TfNSW reference: REN25/00067/009

**SSD-85372970 - Griffith Battery Energy Storage System; 15 Bob Irvin Road, Yoogali; Griffith City Council; Response to Environmental Impact Statement**

Transport for NSW (TfNSW) is responding to the exhibition of the Griffith BESS, which was exhibited on 20 November 2025 and was referred via the Major Projects Portal.

TfNSW has reviewed the Environmental Impact Statement (EIS) prepared by cogency dated 12 November 2025 and the Traffic Impact Assessment (TIA) prepared by Onemilegrid dated 12 November 2025, as key documents for preparing this response.

Figure 17 Heavy Vehicle Access Routes

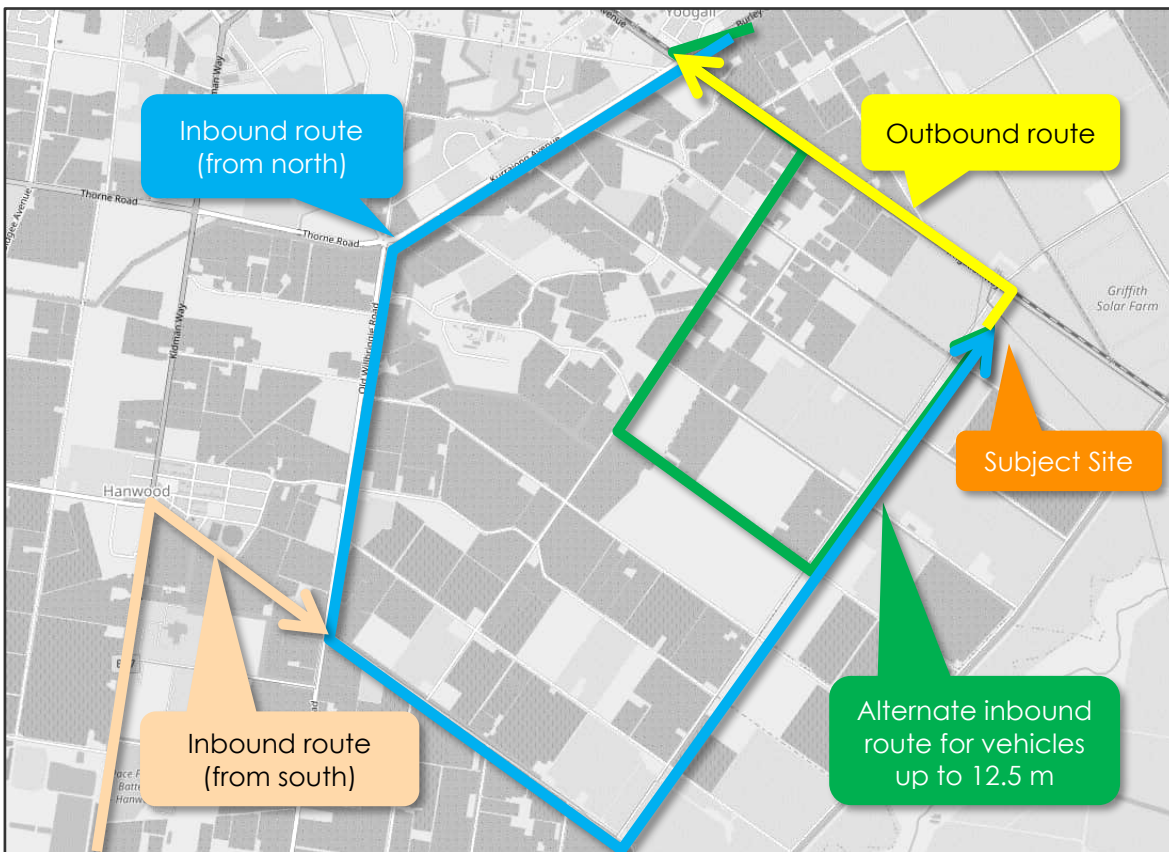
No.	TfNSW comments from EIS requiring RFI
<b>Key Issue 1 – Access Intersection Assessments</b>	
	<p>Figure 17 of the TIA proposes utilising a four-state road intersection as part of the project's construction traffic routes; each intersection must assess the traffic requirements stated in TfNSW's SEAR response to the proposed project. Currently, the TIA only addresses the four-way intersection of <u>Irrigation Way / Bob Irvin Way</u>; however, an assessment of <u>Kidman Way/Hanwood Avenue</u>, <u>Murray Road / Irrigation Way</u> will also need to be provided.</p> <p>The following further assessment is required for <u>Kidman Way/Hanwood Avenue</u> and <u>Murray Road / Irrigation Way</u>:</p> <ol style="list-style-type: none"> <li>a) Swept paths are required, demonstrating the largest vehicle to use the intersection. Must be prepared in accordance with <i>Austroads Design Vehicles and Turning Path</i></li> <li>b) A turn warrant assessment for different scenarios (i.e project peak hour is different to network peak hour, for the worst case scenario (i.e overlap of construction, pre-construction works and occupation of stages of workforce accommodation camp).</li> </ol> <p>The turn warrant assessments are to be prepared in accordance with section 3.25 of Part 6 of the <i>Austroads Guide to Traffic Management</i>. A turn warrant assessment will be required for each scenario identified above and for each access, access track and any other access along the project's identified routes with an interface or connection to the state road network.</p> <p>The methodology to be used for the turn warrants assessment is:</p> <ul style="list-style-type: none"> <li>• Applied to existing AM/PM network peak background traffic,</li> </ul>

Figure 20 Proposed OSOM Route to Port Kembla (NHVR Route ID 2NZHH-0 v1)

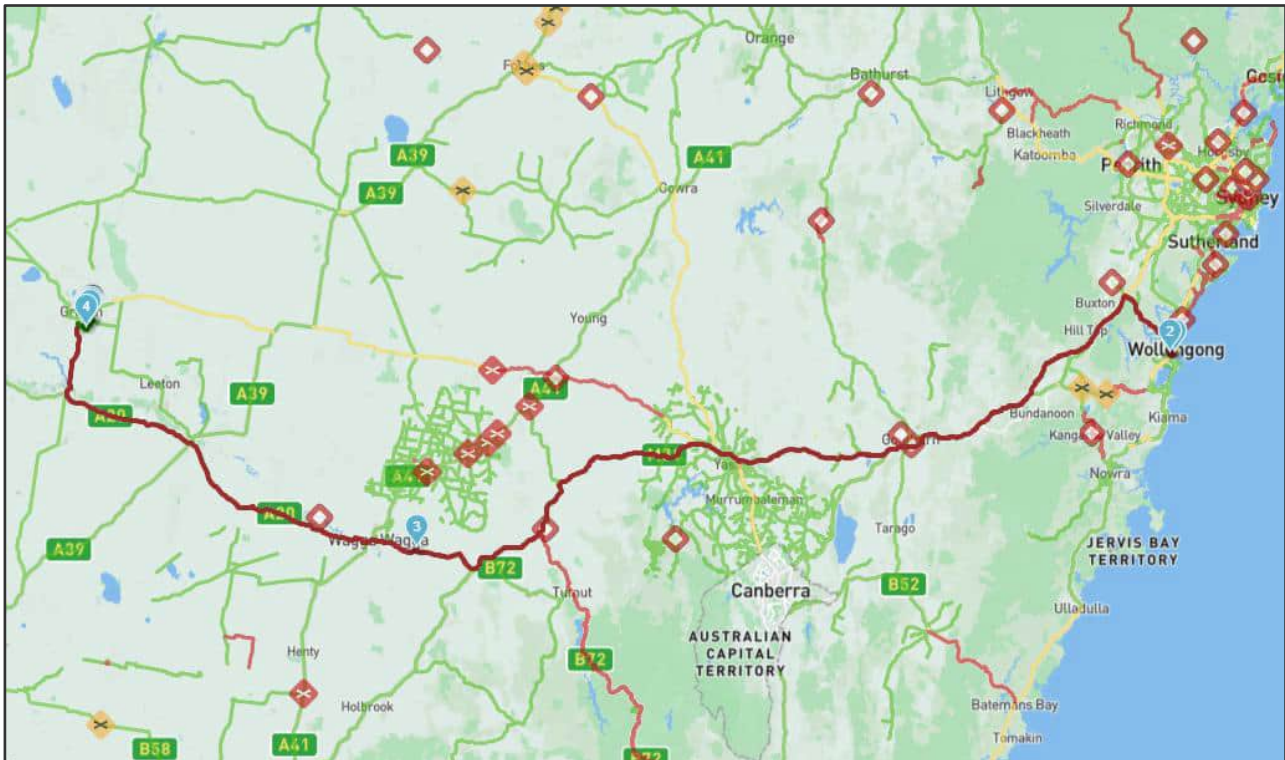
5.	<p>The proponent has confirmed in Table 9 that high-risk oversized overmass (OSOM) vehicles are required. Detail regarding these movements is requested to ensure the compliance of the road upgrades and mitigation measures in accordance with the Austroads Guide to Road Design, the Austroads Guide to Temporary Traffic Management, and TfNSW requirements. This should include:</p> <ul style="list-style-type: none"> <li>a) The high-risk OSOM laden loads, class and vehicle configuration must include the following information regarding the dimensions, weight and length: <ul style="list-style-type: none"> <li>• Overall dimensions (width, height and length) of the <b>laden</b> load (laden load is the vehicle combination and the load to be transported),</li> <li>• Total weight of laden load,</li> </ul> </li> <li>b) Swept paths for pull-over bays / rest areas along high risk OSOM routes (including GPS coordinates) that demonstrate that high risk OSOMs can be physically accommodated for the project (in terms of size, width and accessibility).</li> <li>c) Bridge Assessments for any at risk bridges on classified roads due to dimensions and weight of OSOM vehicles, contact <a href="mailto:spu@transport.nsw.gov.au">spu@transport.nsw.gov.au</a> to request a bridge assessment of TfNSW assets.</li> </ul>

INTERSECTION OF:
STURT HIGHWAY AND NEWELL HIGHWAY
GILLENBAH

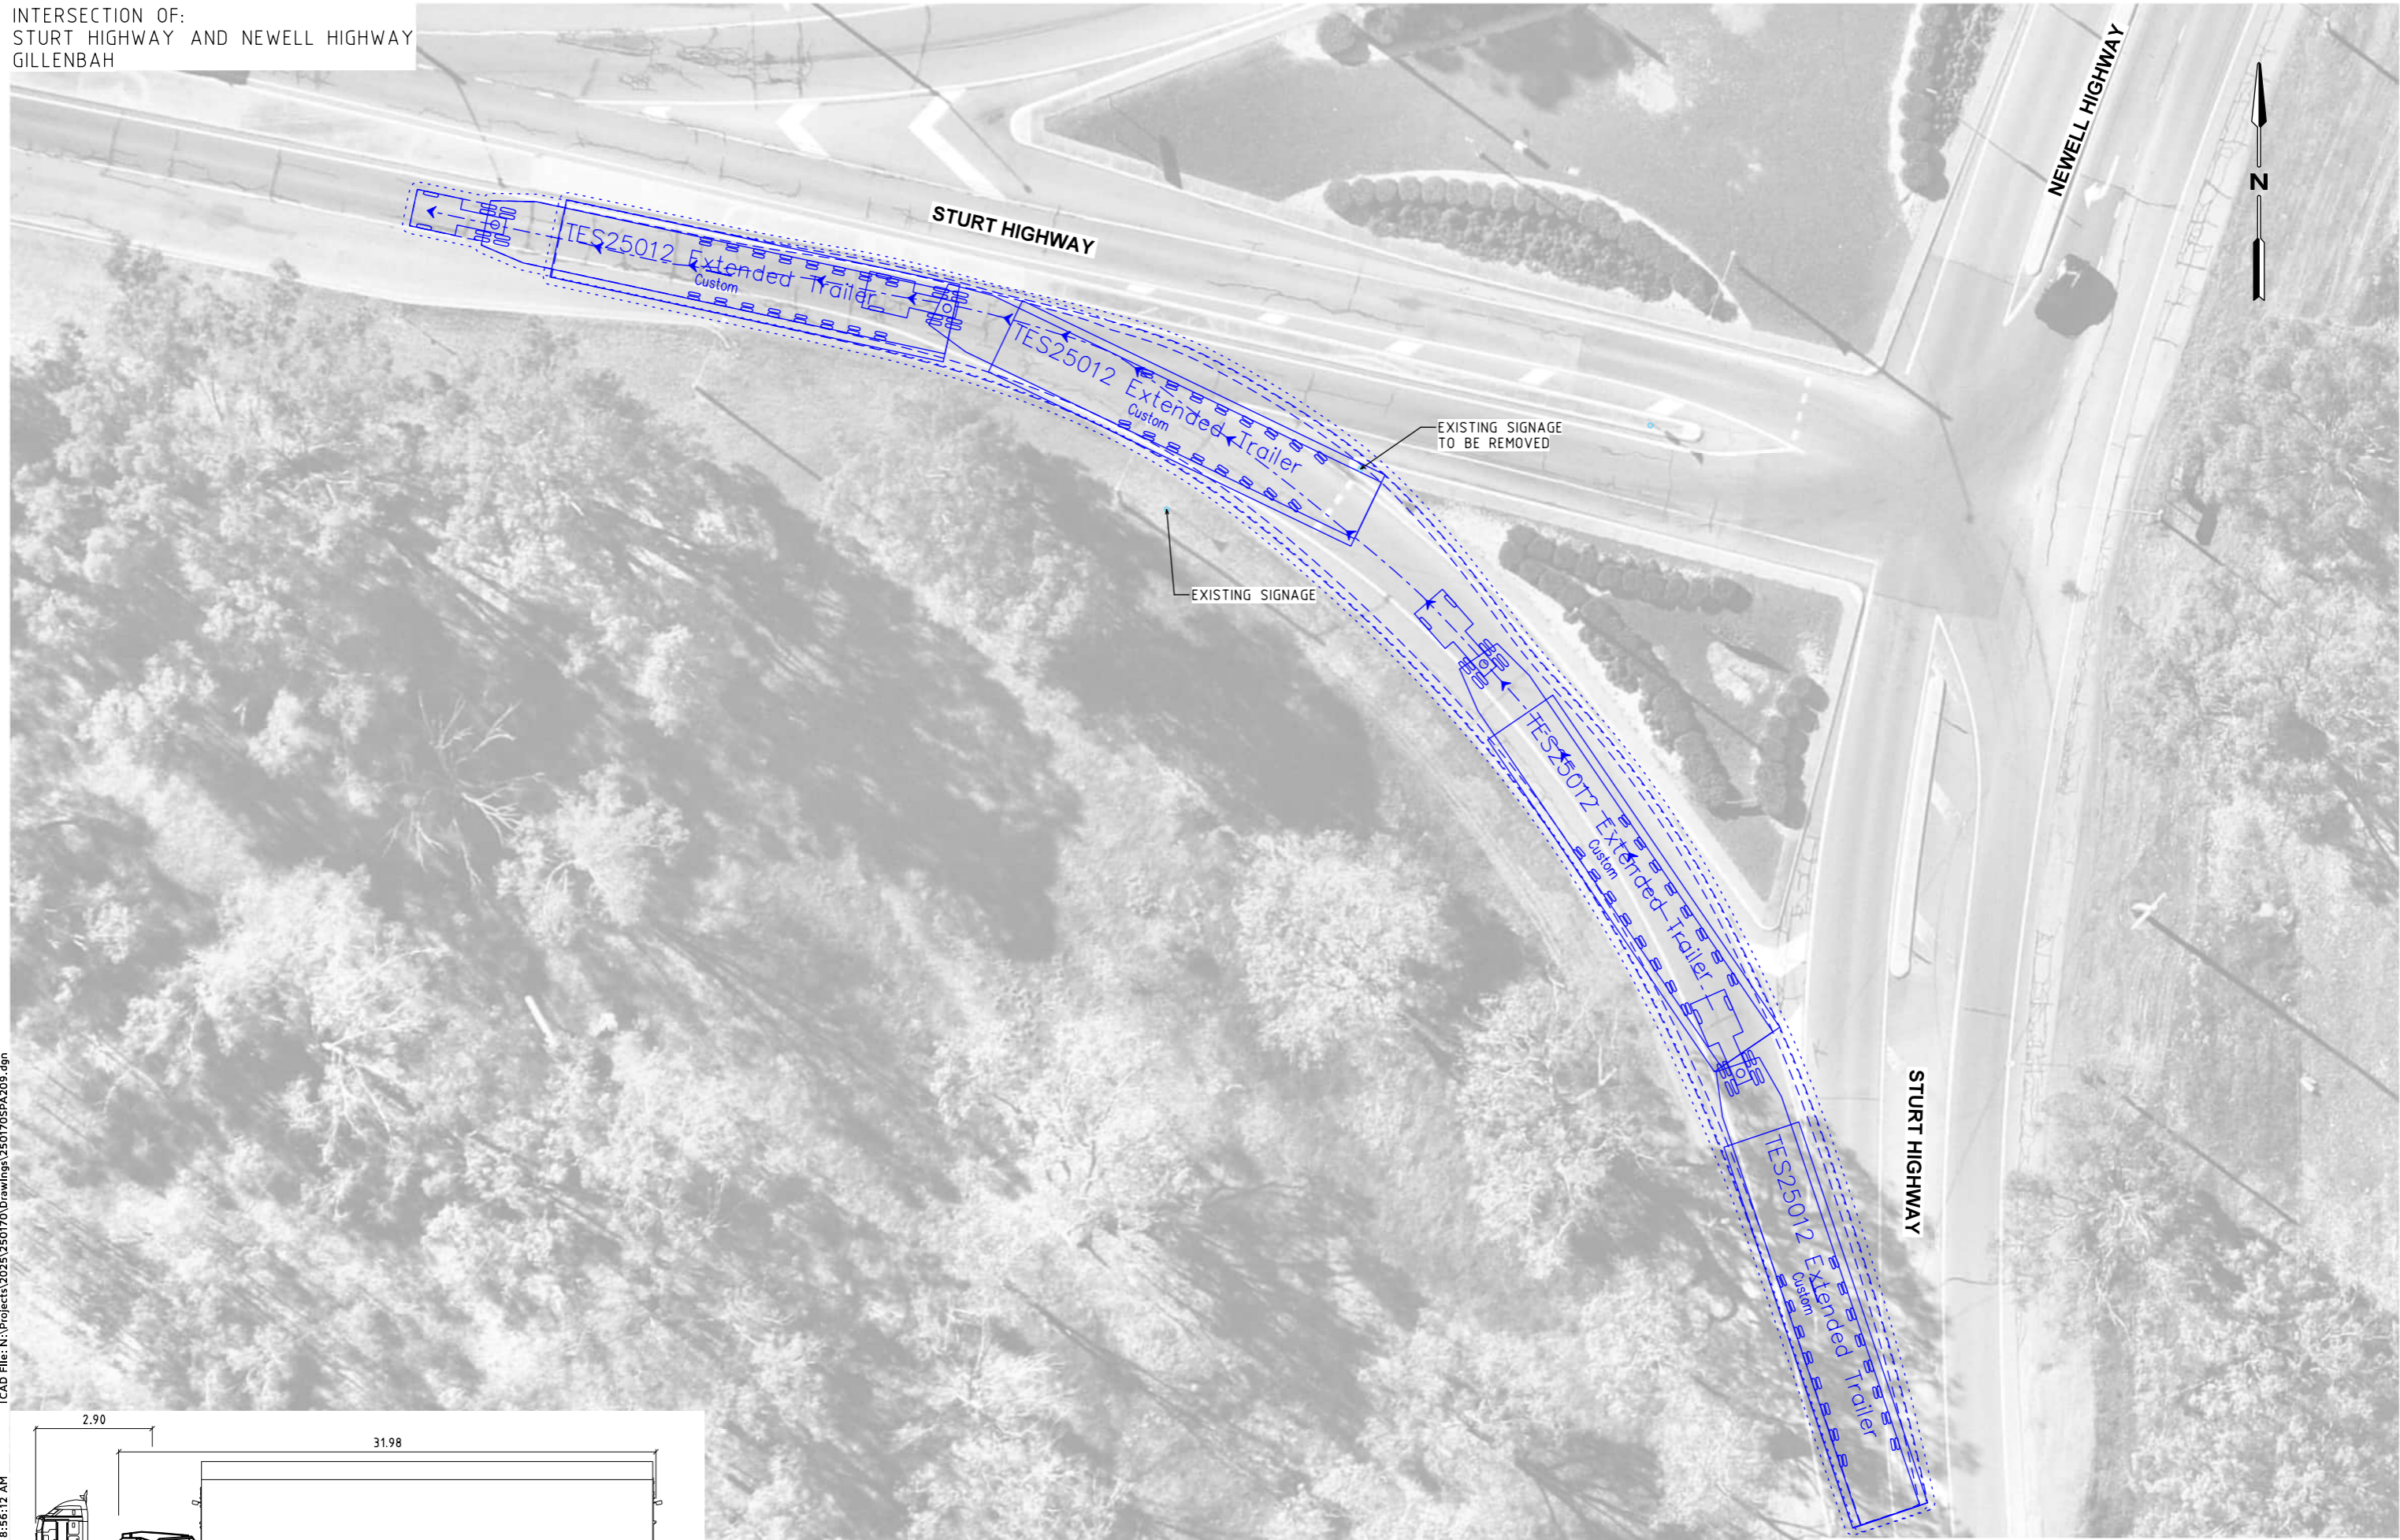
<p>d) Highlighting each at-risk road structures that the haulage route crosses. There are locations on the provided route study that require further information:</p> <ul style="list-style-type: none"> <li>- corner of Sturt Highway and Newell that appear to demonstrate the wheels tracking over the concrete median. It must be clarified if these wheels are tracking on the median. If so, strategic concept designs for works will be required. See Appendix 2.</li> <li>- Formation widening will be required at the intersection of Hanwood Avenue and Bob Orvin Road. It is noted that the swept path analysis shows the OSOM vehicle tracking within 0.5m of the existing power pole and within 0.5m of drainage infrastructure. Strategic plan required for this location.</li> </ul> <p>Height Restrictions:</p> <ul style="list-style-type: none"> <li>- University Avenue Bridge over F6 – Min Clearance 4.6m</li> <li>- Bridge on Gipps Rd over F6 West Wollongong – Min Clearance 5m</li> <li>- Bridge over F6 Reserve Street – Min Clearance 5.3m</li> <li>- Pedestrian Bridge over F6, Near Byarong Ave – Min Clearance 5.3m</li> <li>- Bridge on Sierra St over Hume Hwy, Yerrinbool – Min Clearance 6.2m</li> <li>- Bridge on Church Ave – Min Clearance 5.3m</li> <li>- Bridge over F6 – Mt Keira Rd – Min Clearance 5.4</li> <li>- Bridge on MR 602 Over F6 at Figtree, Min Clearance 5m.</li> <li>- Bridge on MR 602 over F6 at St Thomas – The Avenue Bridge – Min Clearance 5.3m</li> <li>- N/b Load Ramp over SH2 – Min Clearance 5.2m</li> <li>- Railway Bridge over HW14, Wagga Wagga – Min Clearance 5.23m</li> <li>- Bridge over SHE2, Avon Dam Road at Bargo – Min Clearance 5.6m</li> <li>- MWS &amp; DB Pipeline, Bridge over SH2 at Avon Dam Rd – Min Clearance 5.7m</li> <li>- Bridge on Drapers Rd over SH2 at Willow Vale – Min Clearance 5.6m</li> <li>- W/B Roundabout, Bridge over SH2, West of Goulburn, Bridge B – Min Clearance 5.4m</li> <li>- Bridge on MR52, South of Goulburn at Gunning – Sutton Road Overbridge – Min Clearance – 5.8m</li> <li>- Bridge over HW2 Hume, South of Goulburn at Coolalie Road – Min Clearance 5.34m</li> <li>- Bridge over HW2 Hume, 84km South of Goulburn – Min Clearance 5.33m</li> <li>- Pedestrian Bridge at University over F6 at Gwynneville – Min Clearance 5.10m</li> <li>- Bridge on SH14 W/8 over HW2 Hume, Interchange – Min Clearance 5.7m</li> <li>- Interchange Bridge over HW2 Hume, Interchange – Min Clearance 5.73m</li> <li>- Nan – Min Clearance 5.2m</li> <li>- Bridge over HW2, Hume West St Gundagai – West St Interchange – 5.27m</li> </ul> <p>e) Potential high level mitigation measures or commitments to mitigate known traffic, safety and impacts to road users along the high risk OSOM route (i.e school bus routes, mining shift changes, TSRs, harvest periods and events).</p> <p>f) Identify and assess implications of any road and rail projects under construction during the indicative schedule for project related OSOM movements. For example, the Mt Ousley Interchange is a notable project along the route.</p> <p>g) Identify any rail level crossing along the route.</p>
